**MAJOR PROJECT ASSESSMENT:
157 Redfern Street, Redfern
(MP09_0039 MOD 2)**

Director-General's
Environmental Assessment Report
Section 75W of the
Environmental Planning and Assessment Act 1979

November 2011

PLAN OF: **SUBDIVISION OF LOT 1 IN DP1153747**

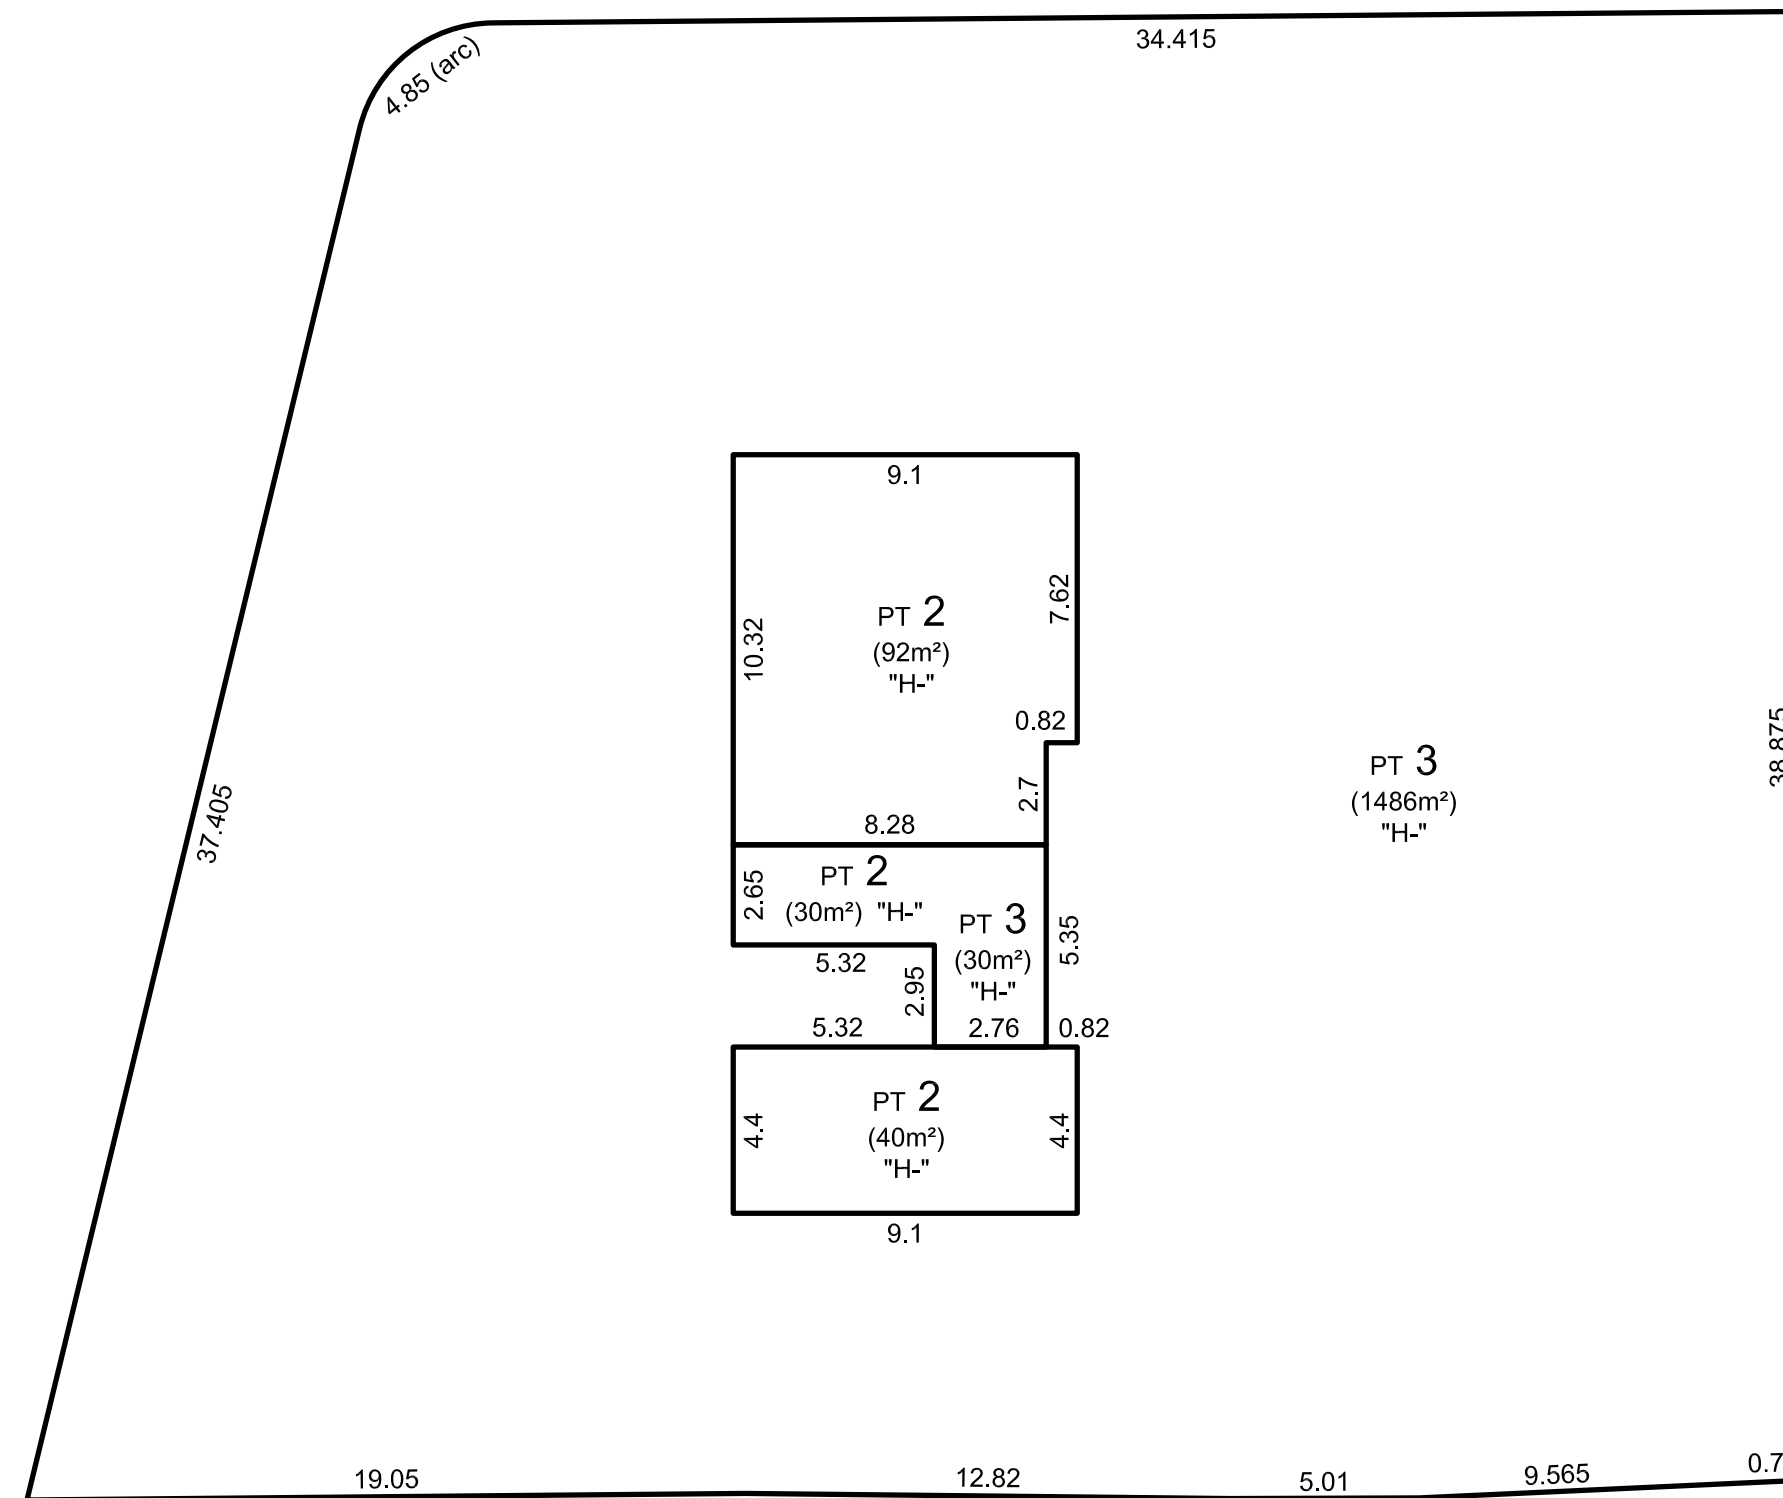
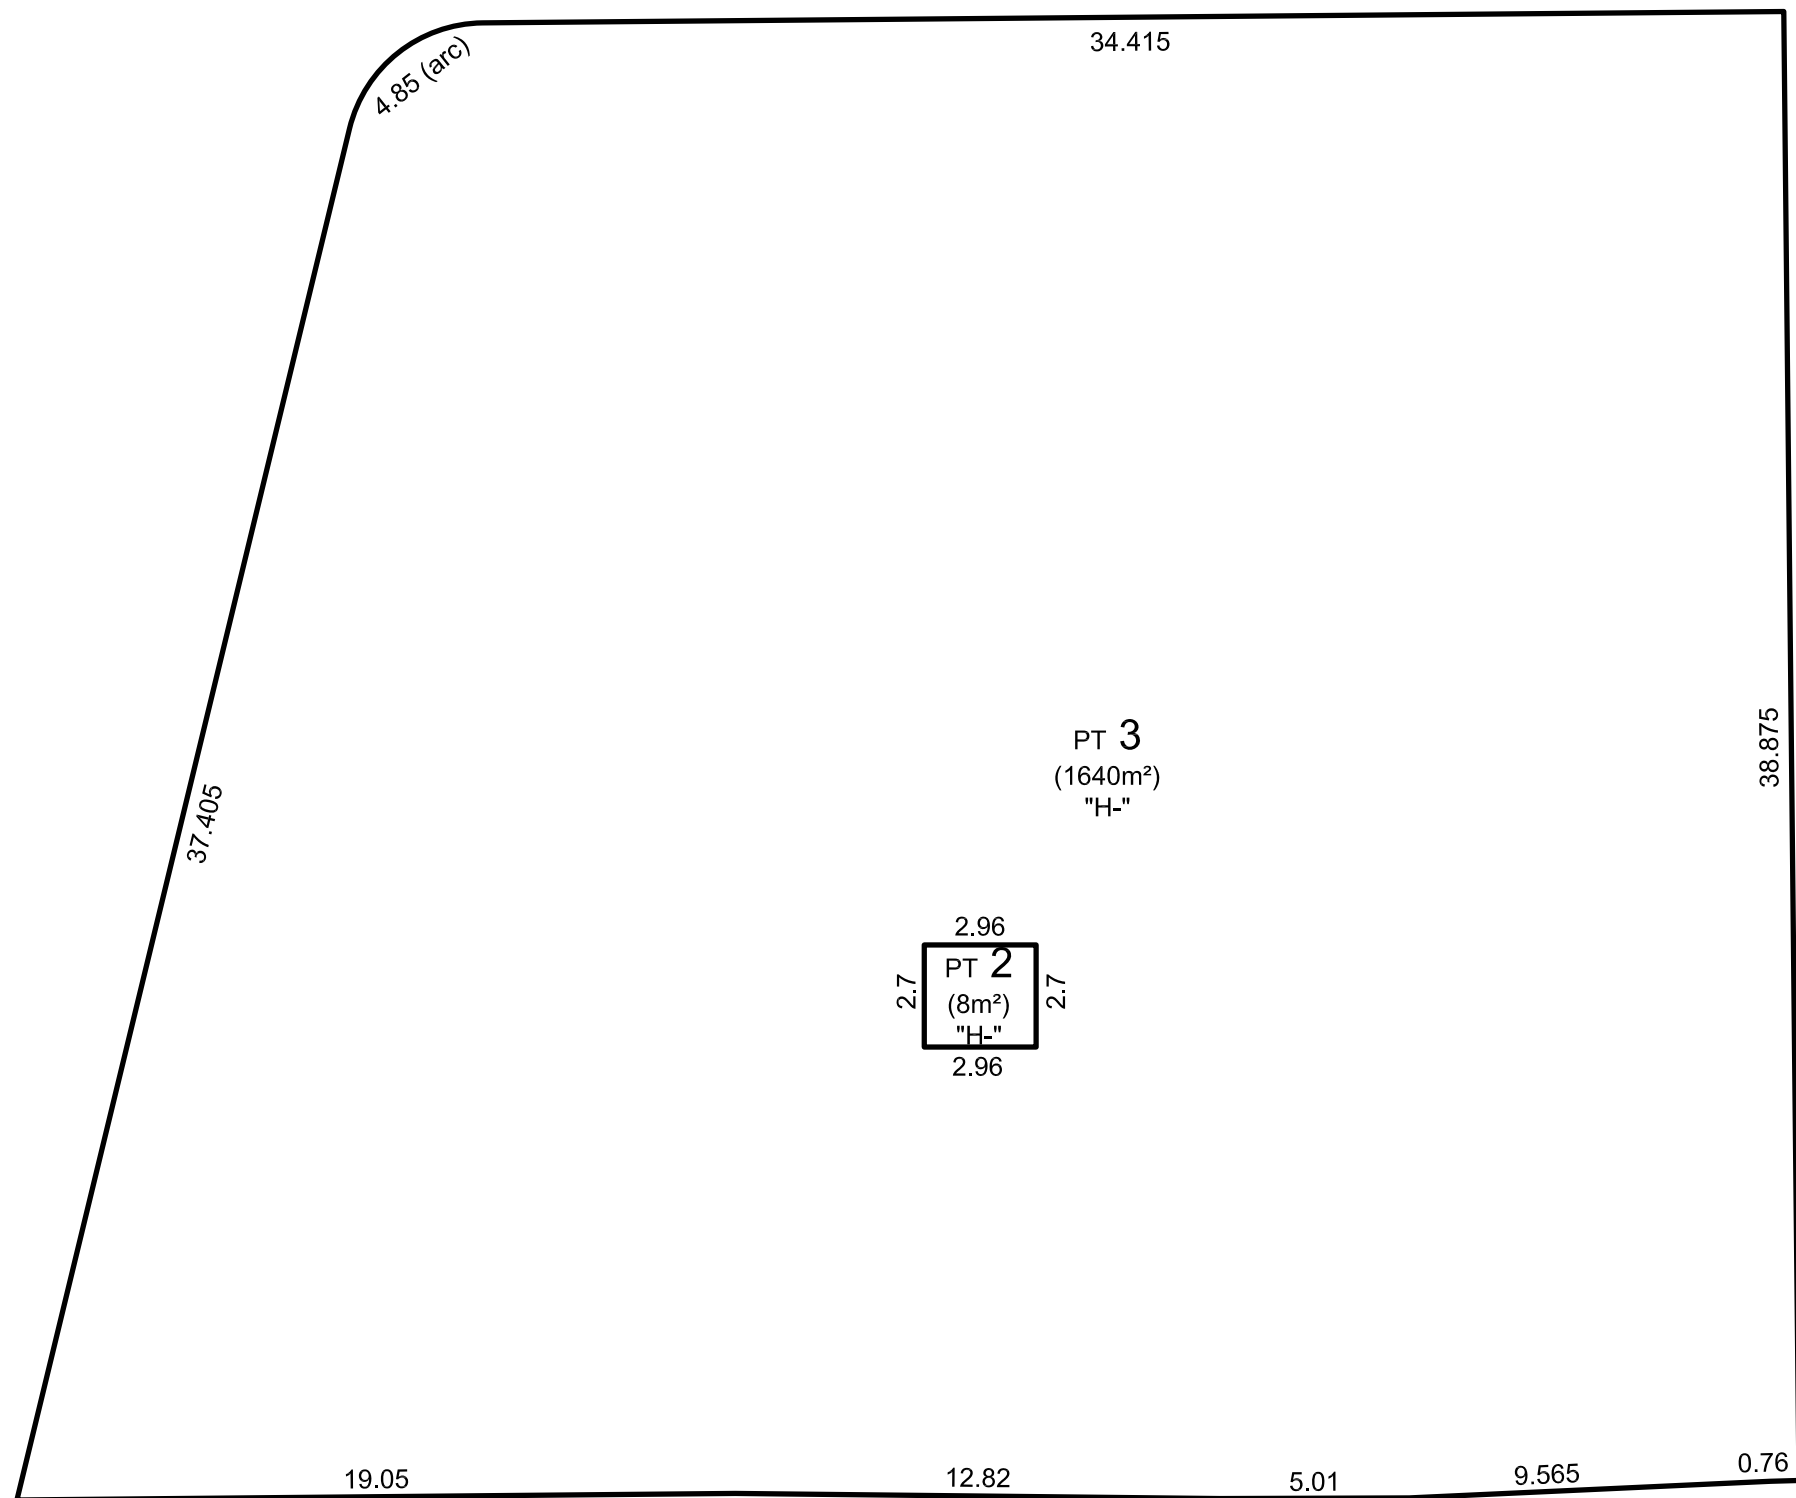
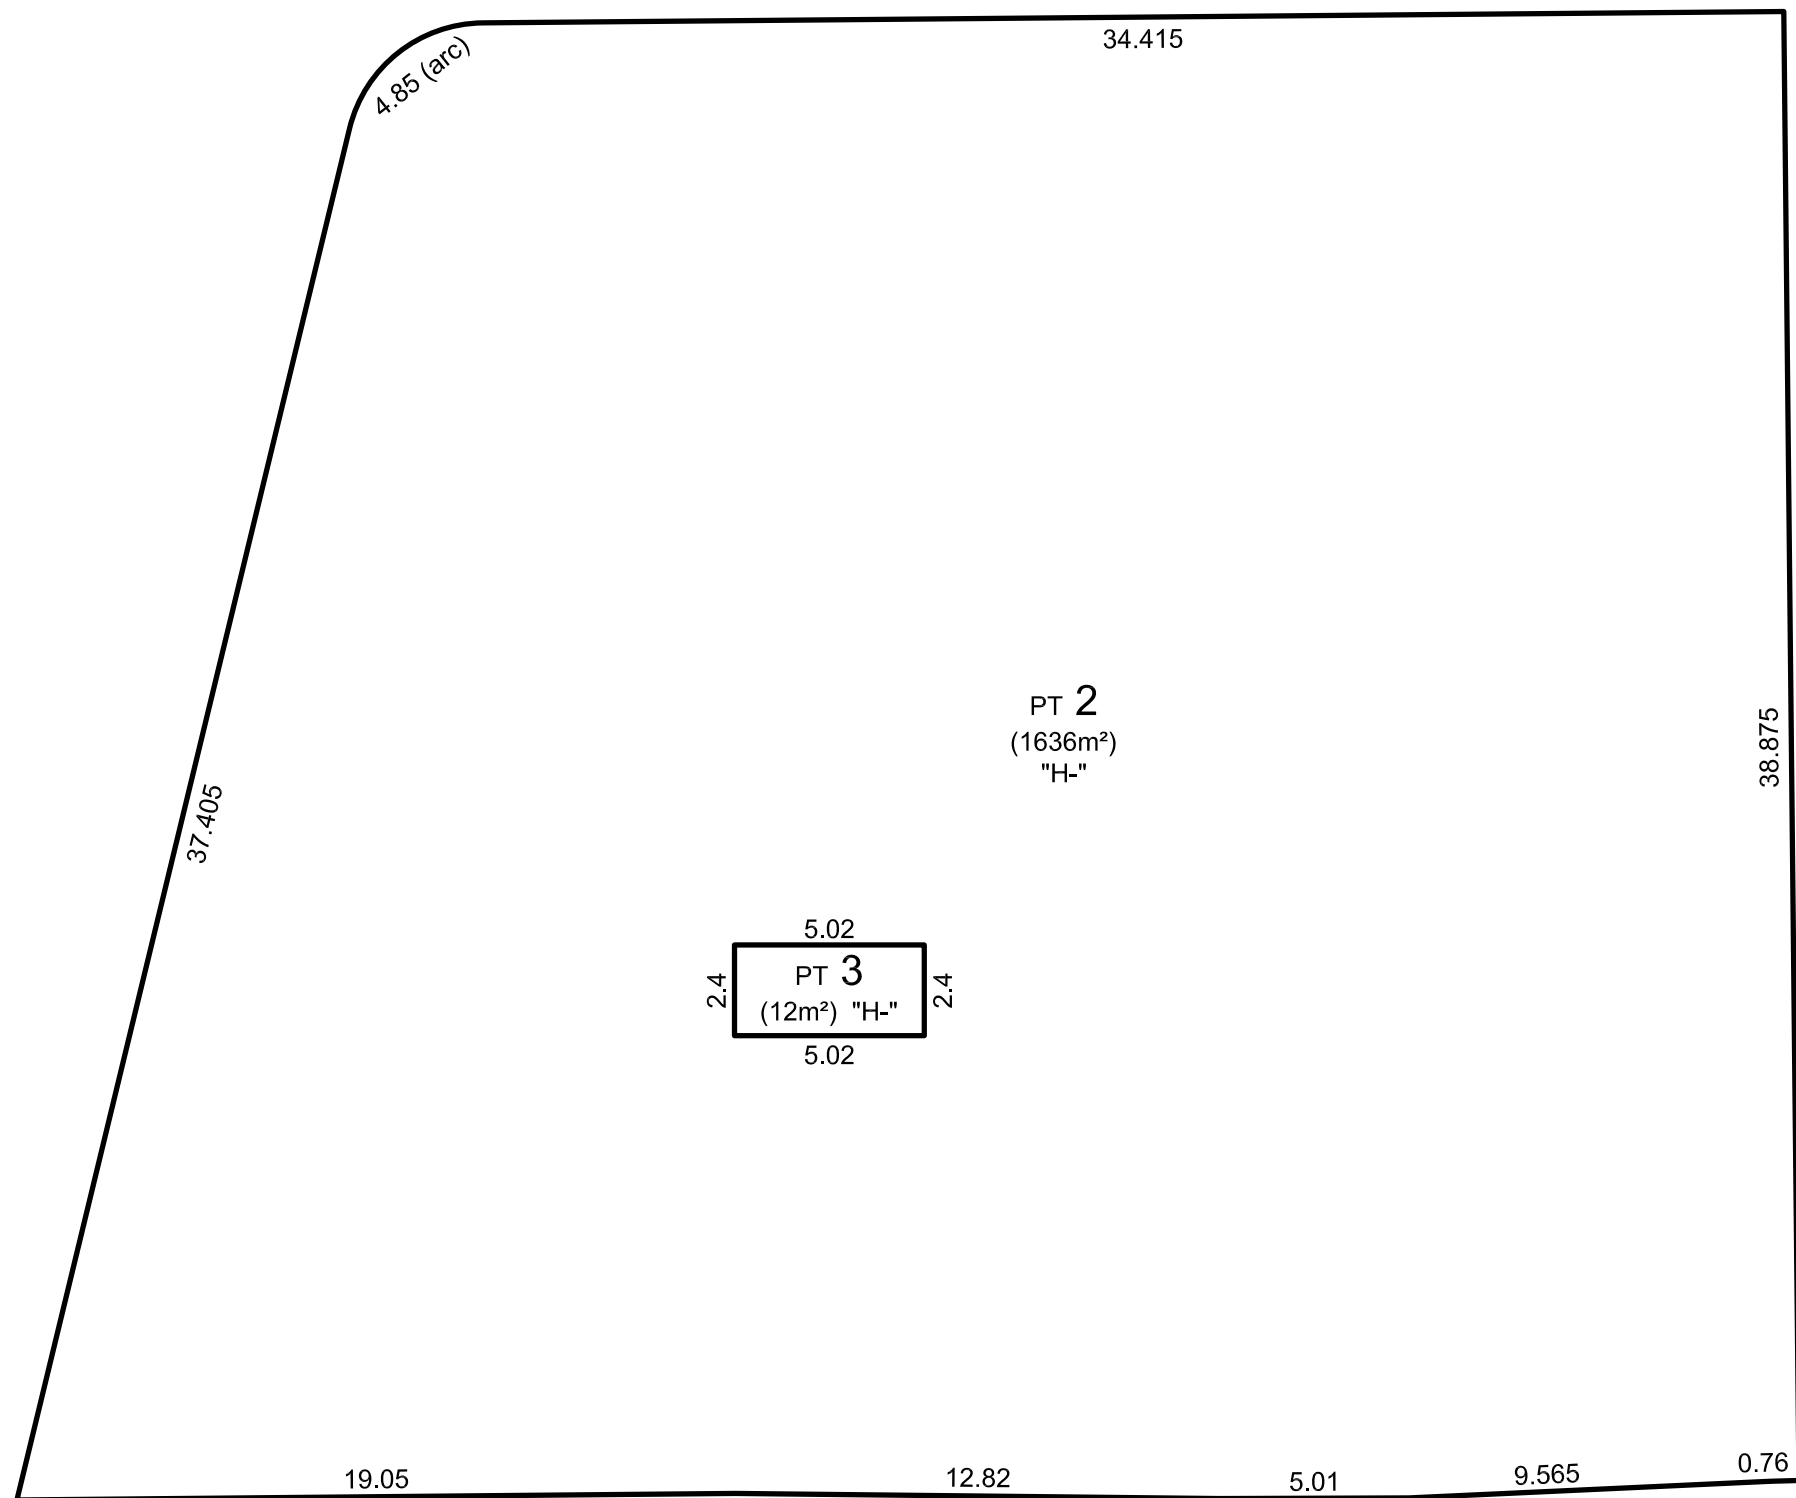
The Proponent requests the residential and commercial office components and respective car parking areas be contained within discrete stratum allotments to facilitate satisfactory and appropriate ongoing management. It is proposed to subdivide into 4 stratum lots, as follows:

- Lot 1 – RSL Club;
- Lot 2 – ground floor retail and two levels of commercial offices;
- Lot 3 – 14 levels of residential apartments; and
- Lot 4 – building services and associated access ways.

The proposed stratum subdivision is considered satisfactory as it will enable the above uses to operate independently and efficiently.
